PLANNING CONSULTATION RESPONSE

Application No	2024/1072
Proposal	Single storey side and rear extension to 2 storey semi-detached dwelling
Address	31 Mill Hill, Wombwell, Barnsley, S73 8SJ
Date of Consultation Reply	18 th December 2025
Consultee	Highways DC

[2nd Response]

PROPOSED GROUND FLOOR PLAN
SCALE 1:50

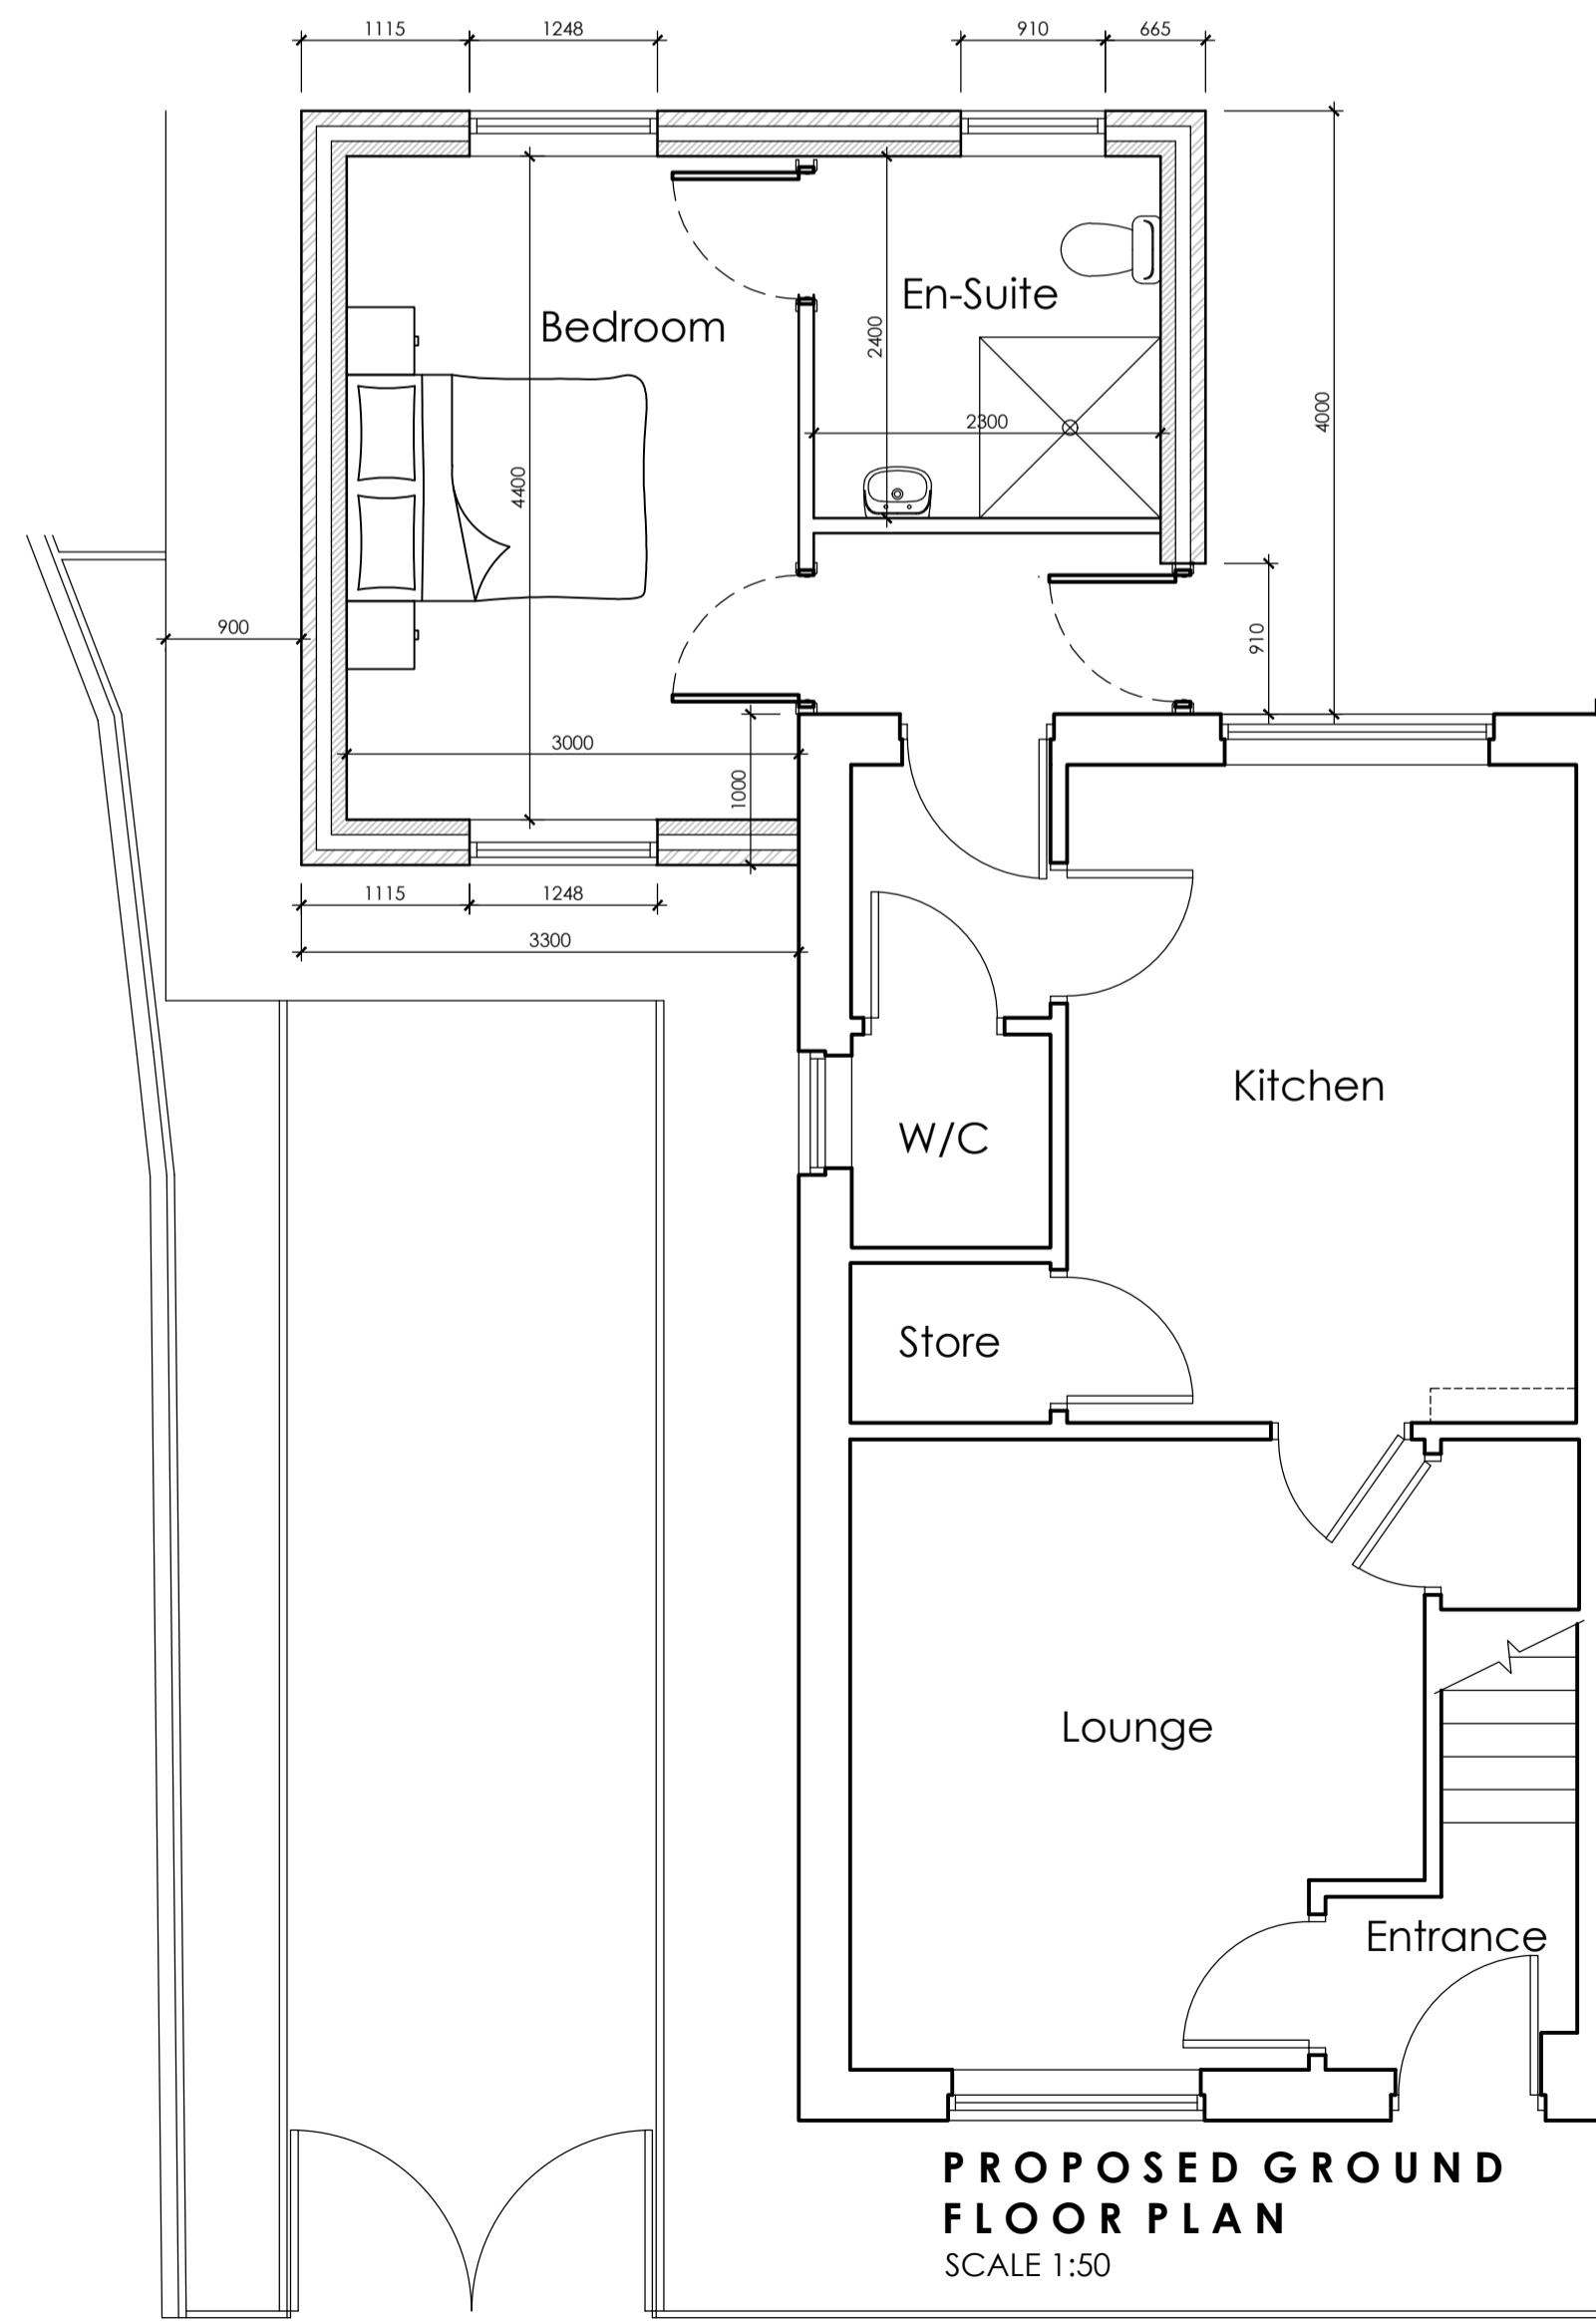
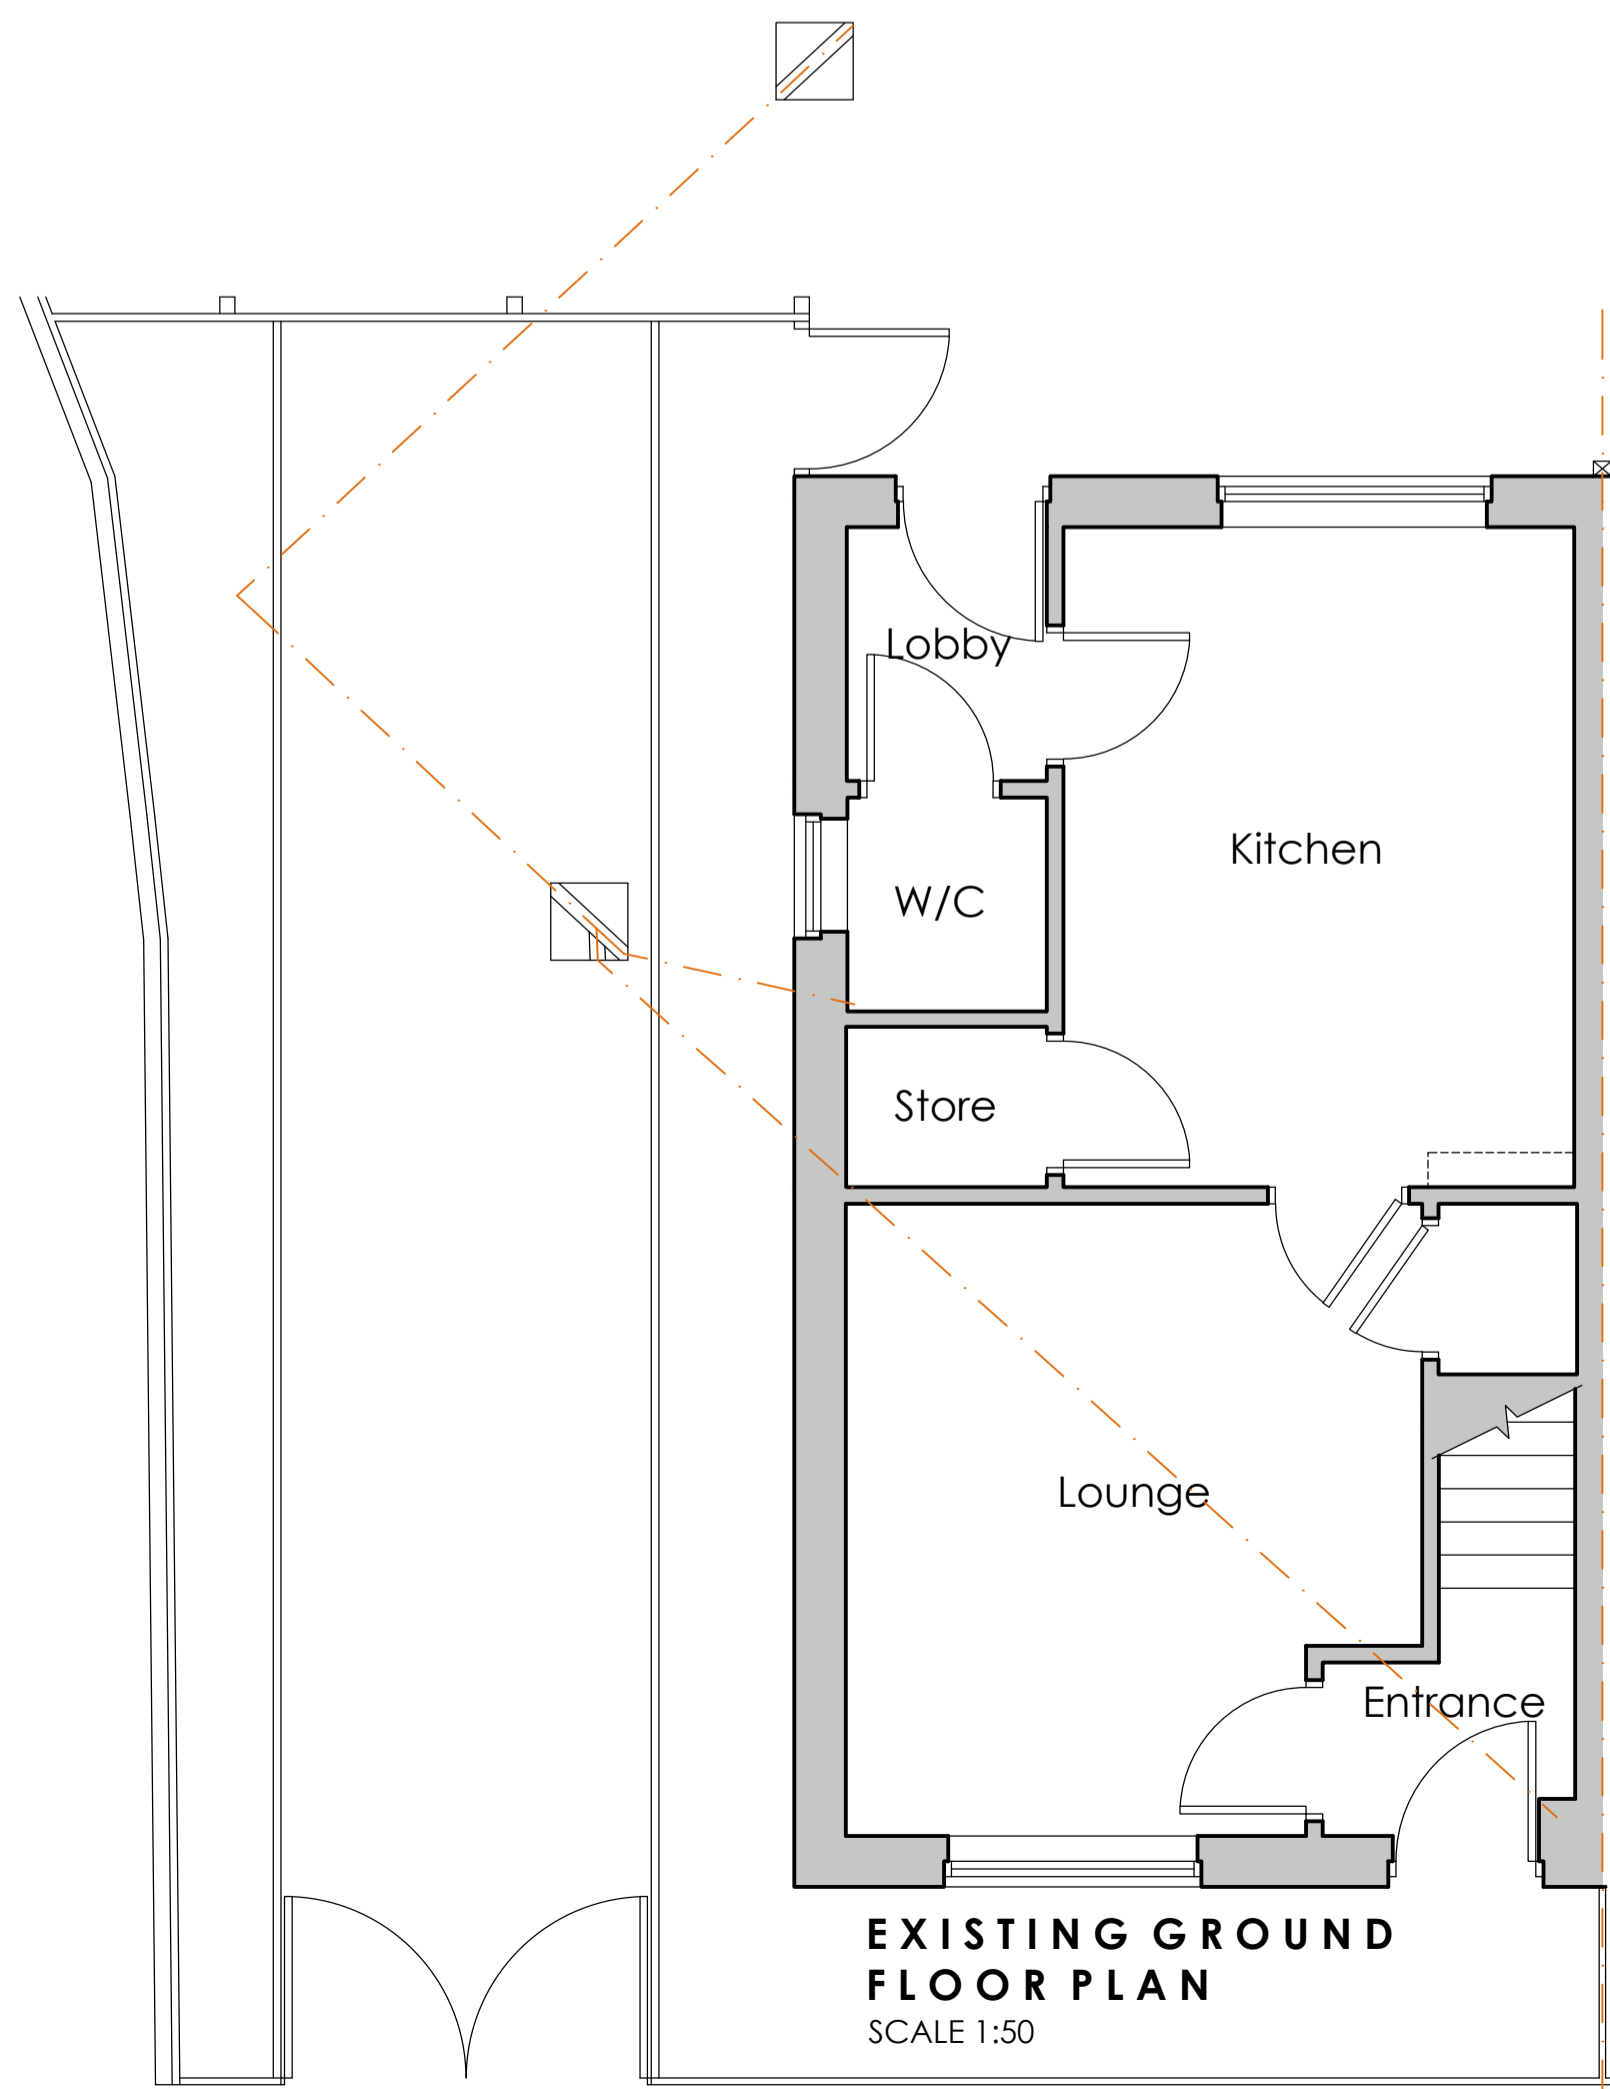
With reference to the submitted drawing 24-120 04, it can be seen that the proposed side extension has now been positioned further back into the site, almost to the rear elevation of the house, in order to maximise the retained driveway length. Given the location of the site at the head of a cul-de-sac with minimal vehicular and pedestrian movements, it is considered that the proposed off-street parking arrangements are sufficient to serve the site.

In view of the above, I do not wish to raise an objection from a highways development control perspective, subject to the condition below, which I would be grateful if you could include should you be minded to grant permission.

Any gates shall be hung so as to only open inwards and be permanently retained as such for the lifetime of the development.
